10 October 2023

Department Ref: SSI-36656827

APA Ref: 502715

**RE: Submission on Humelink**

FIGURE 1-1: Location of the project

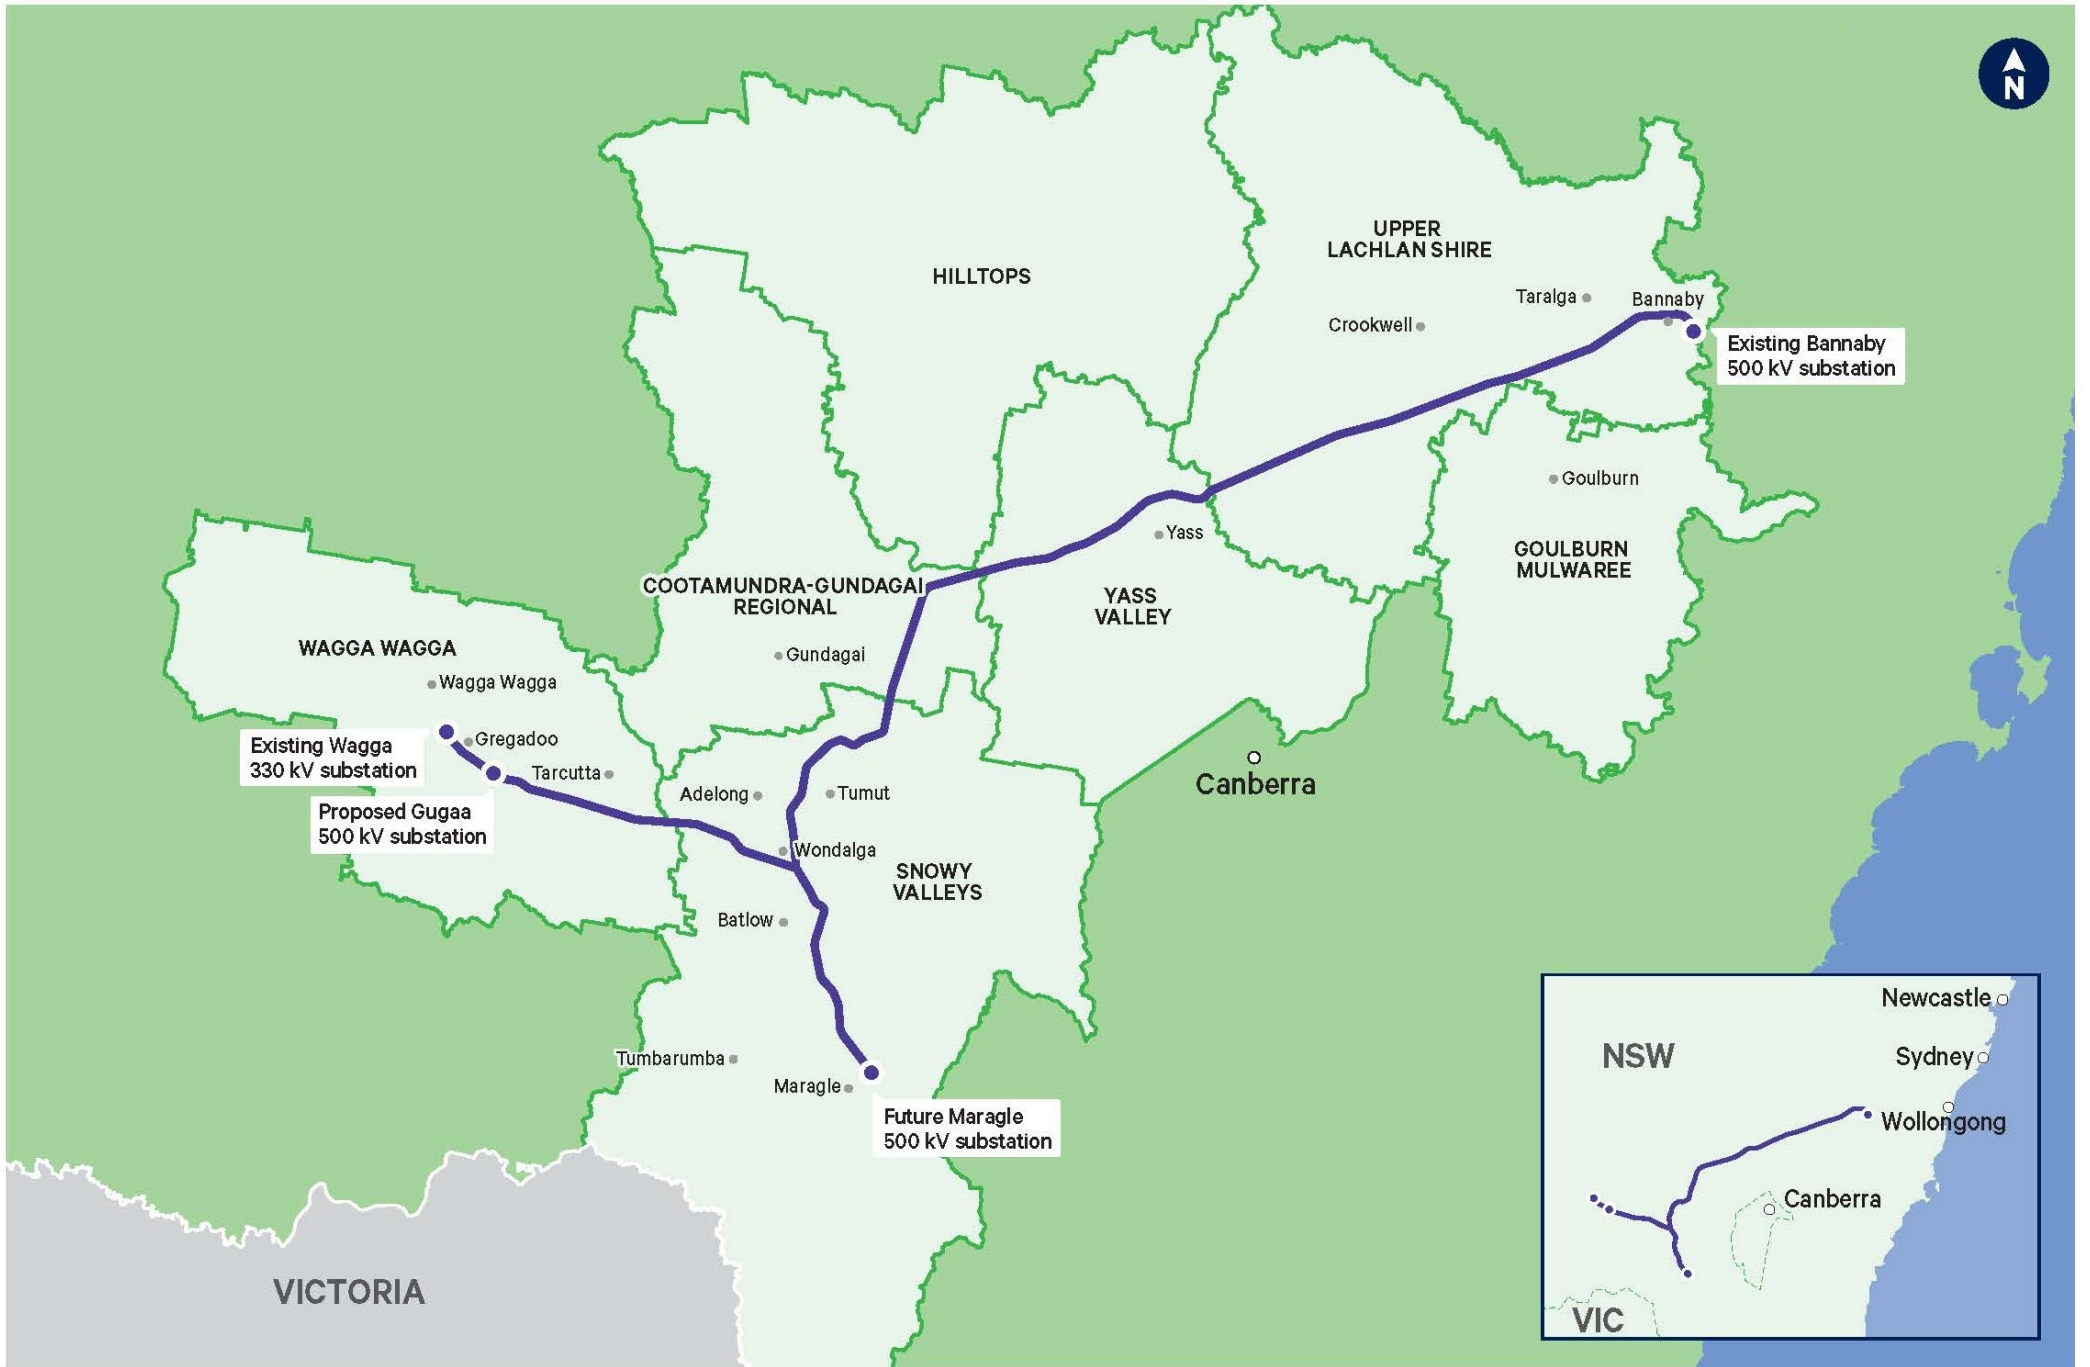
Figure 1-1 of the HumeLink Scoping Report prepared by Aurecon dated 11 Feb 2022 does not include APA's infrastructure "high pressure gas transmission pipelines", nor is there a specific consideration of the HPGTP within the Environmental Scoping Report. All plans associated with this development must include the gas pipeline easement so that construction workers, and associated contractors are aware of the gas pipeline and its location.

All plans which include the area of the gas pipeline easement must have the easement clearly identified with hatching on the full width of the easement. The easement must also be clearly labelled as *'high pressure gas pipeline easement – no works to occur without the prior authorisation of the pipeline operator'*.
